CITY OF PORTLAND, MAINE
HISTORIC PRESERVATION BOARD

November 9, 2015

Re: 133 Spring Street – seasonal entry enclosure

Temporary Winter Vestibule Permit, v2 10/20/2015
BaoBao Dumpling House
133 Spring St., Portland, ME

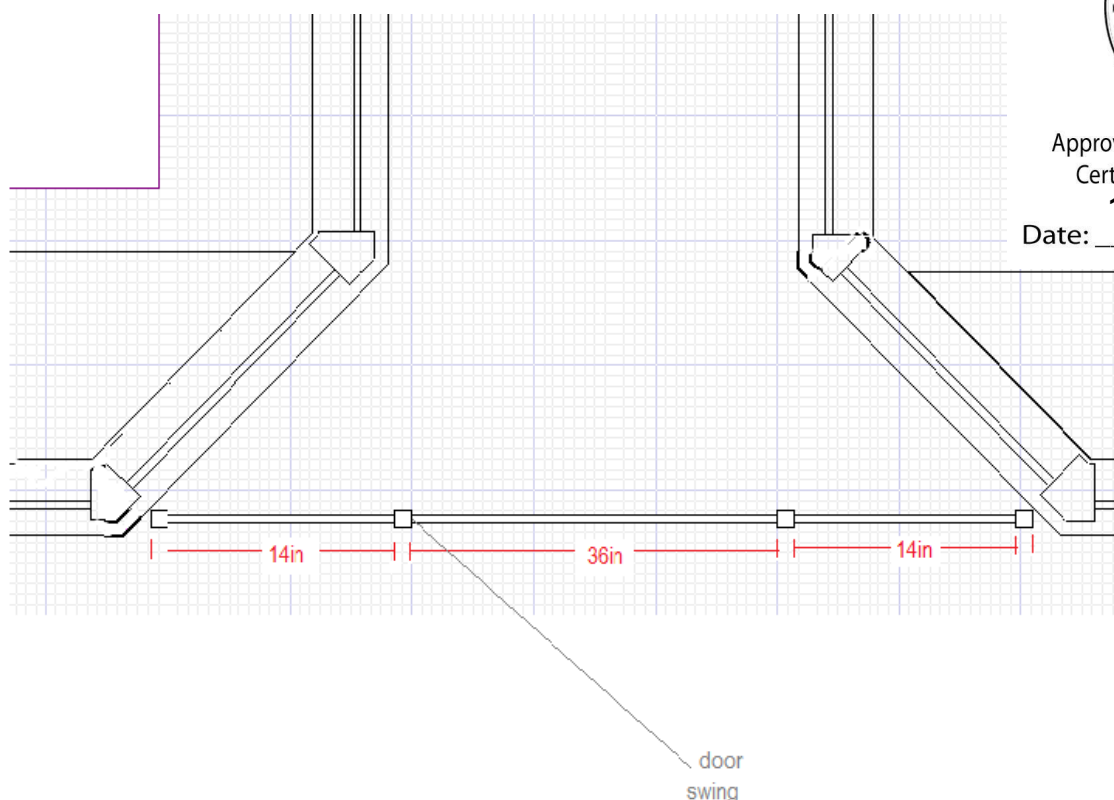
1. Revised layout and details of the attachment system are to be submitted to HP staff for final review and approval prior to construction.
2. Installation of the proposed enclosure shall be seasonal: to be installed no earlier than October 1 of each year, and removed no later than April 30 the following Spring.
